From: wilpshire parish council <wilpshireparishcouncil@gmail.com>
Sent: 05 February 2026 13:40
To: Planning; wilpshire parish council; wilpshire council
Subject: Comments re consultation for 3/2025/0801 Salesbury View Wilpshire
Attachments: IMG_8741.jpg

Further to a re - consultation in respect of amended plans for planning application 3/2025/0801 - Salesbury View, Wilpshire[submitted by Persimmon Homes] please see below comments from Wilpshire Parish Council:

Wilpshire Parish Council wishes to further object to the above application for the following reasons:

WATER MAINS RECORDS

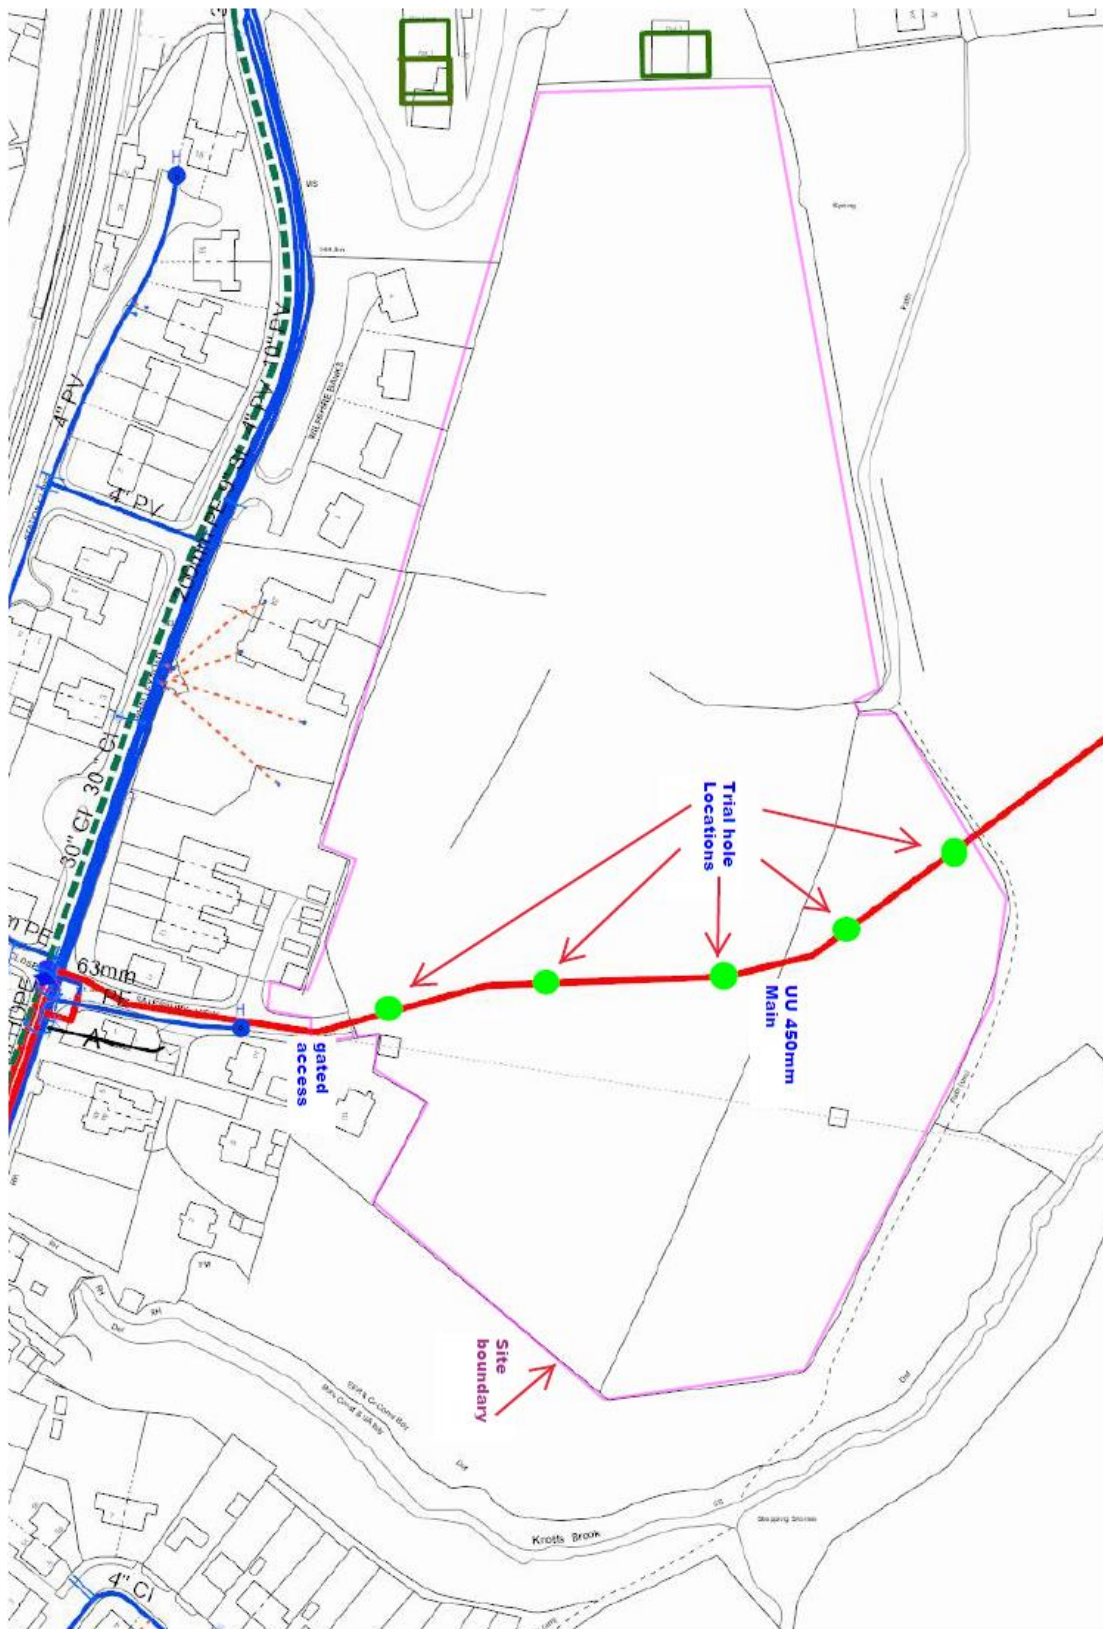
3-The PC has noted that United Utilities have not lifted their objection due to their water pipes (as per photo) going through the site not just north/south along any access road but the turning east/west through the site.

The PC would like to establish that United Utilities are fully aware of their assets potentially being built over without proper assessment and note that Persimmon should not rely on detail of UU asset maps.

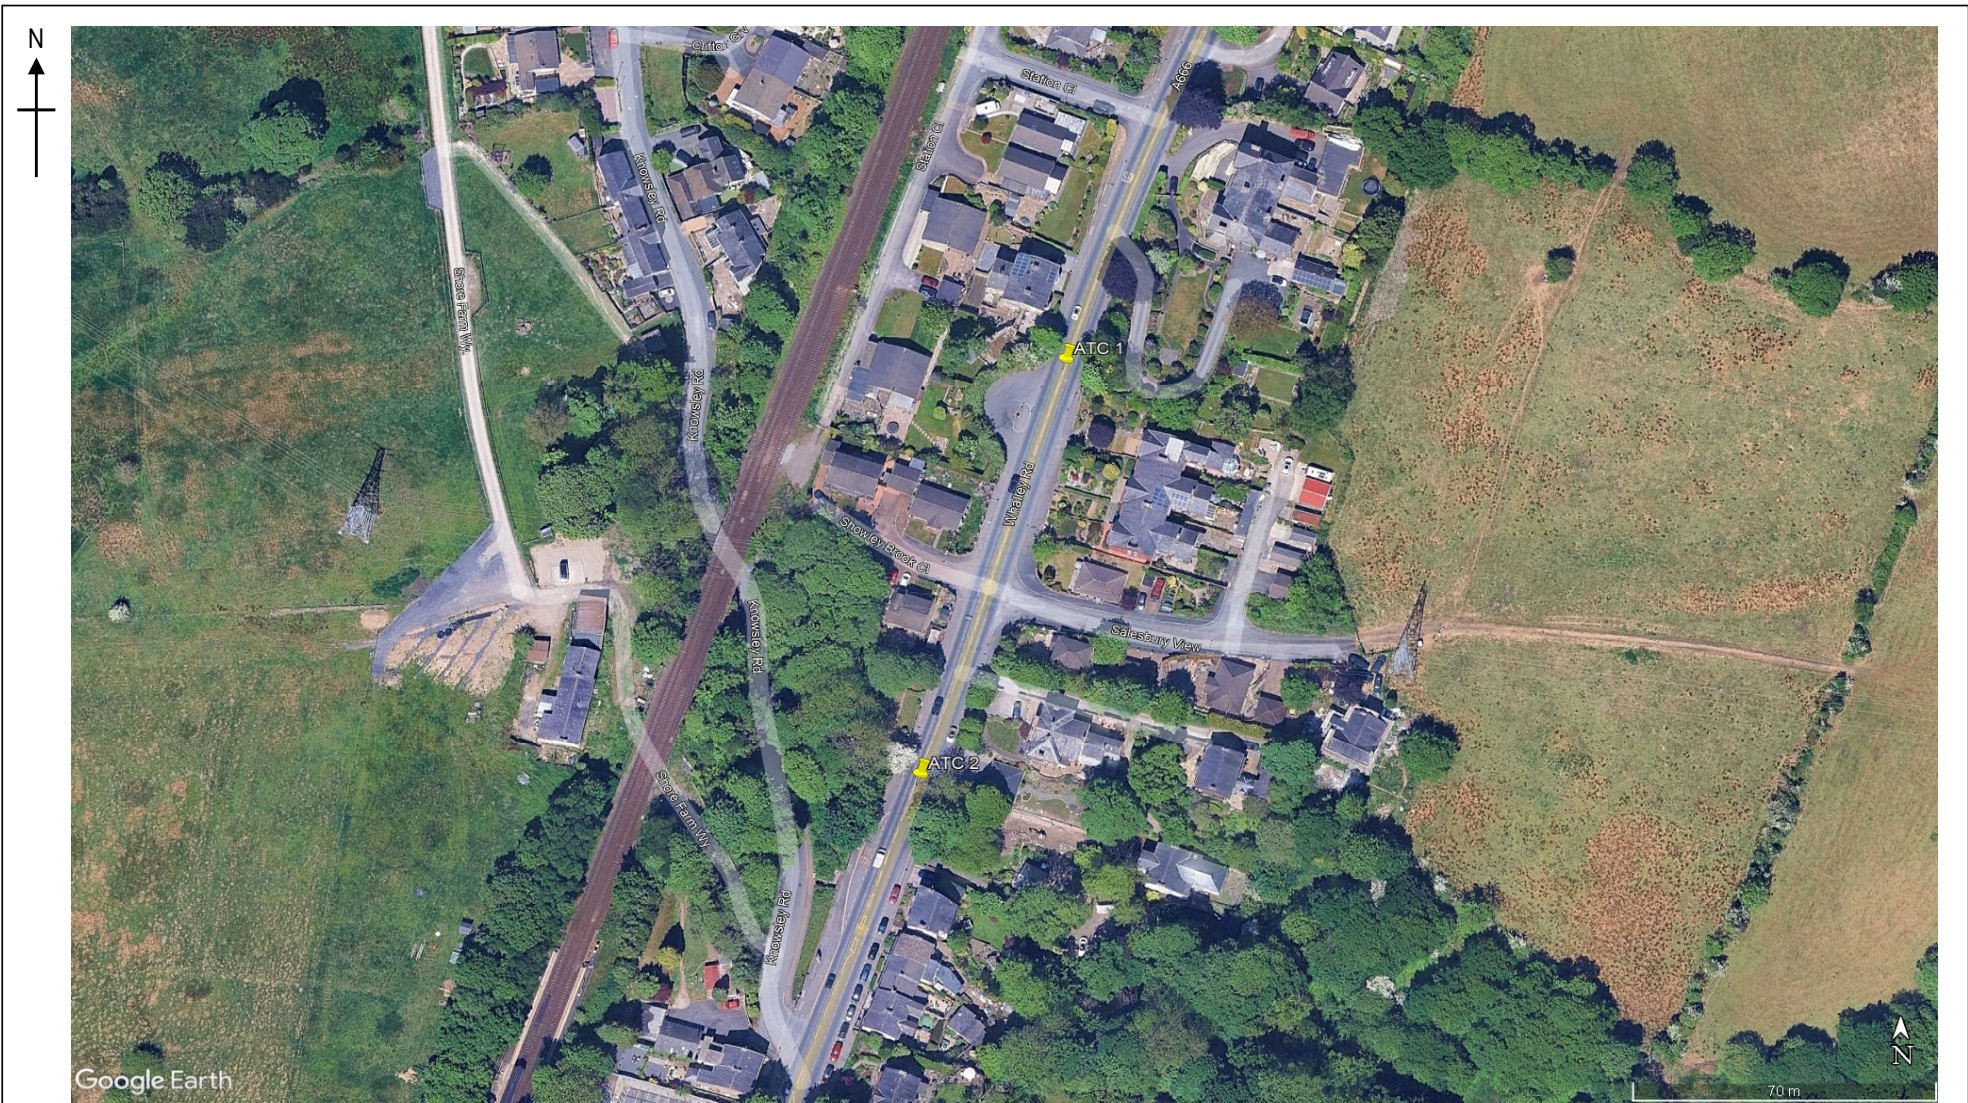
2-The PC would like an up to date traffic assessment to be carried out and submitted as it believes that the one submitted by Persimmon Homes did not show the true nature of speeding on this part of the A666.

Persimmon statistics for their traffic assessment is contrary to WPC's own independent SPID assessment.

Persimmon had a highest speed stat at 45mph whereas WPC recorded 80mph in a 30 mph zone.
